Sydney Metro Design Review Panel

Pitt Street ISD

Advice and Actions Record – 04 & 05 May 2020

Figure 1 Typical Level 10 Balustrade

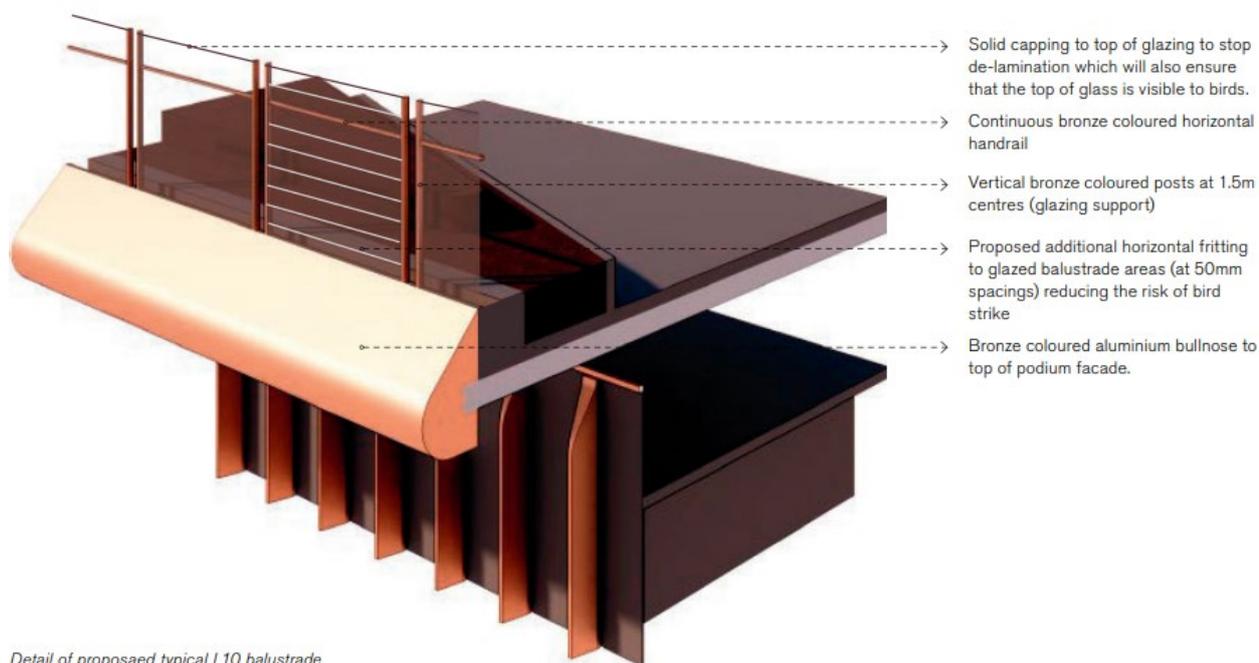
7.05	OSD North	Built Form	31/03/2020	DRP 7 Presentation	<p>Building Envelope</p> <p>The Panel accepts the building envelope as presented with the exception of the 1.8m high balustrades on the top of the podium.</p>	Project Team	21/04/2020 05/05/2020	<p>This item seeks review of the proposed 1.8m glass balustrade solution</p> <p>The Panel supports the glass balustrade and efforts made to reduce its perceived height internally and externally.</p>	Closed

7.06	OSD North	Built Form	31/03/2020	DRP 7 Presentation	<p>Further Wind Study</p> <p>The Panel is concerned that screening the podium setback on the corner with 1.8m glass balustrade in order to moderate the impact of wind for podium users, will in turn negatively impact the wind conditions on the street that the setback has been designed to mitigate. The panel recommends further wind studies be undertaken to assess this. Refer Item 2.01 for further action.</p>	Project Team	21/04/2020 05/05/2020	<p>This item seeks further wind studies to understand the impacts the increased balustrade height will have on the broader development (i.e.: the podium setback is created to mitigate wind impacts on the public domain through the mitigation of downdraft, yet the high balustrade seeks to provide amenity on the podium roof during windy conditions – what impact will the provision of this balustrade have, if any on the wind at street level?)</p> <p>The Panel accept the wind consultant's opinion that the balustrade will not impact street wind conditions.</p>	Closed

- **Tracker Item 7.05** – The Panel supports the glass balustrade and efforts made to reduce its perceived height internally and externally.
- **Tracker Item 7.06** – The Panel accept the wind consultant’s opinion that the balustrade will not impact street wind conditions.
- **Tracker Item 7.07** - The Panel supports the presented solutions for balustrades to the outside edges of planters.
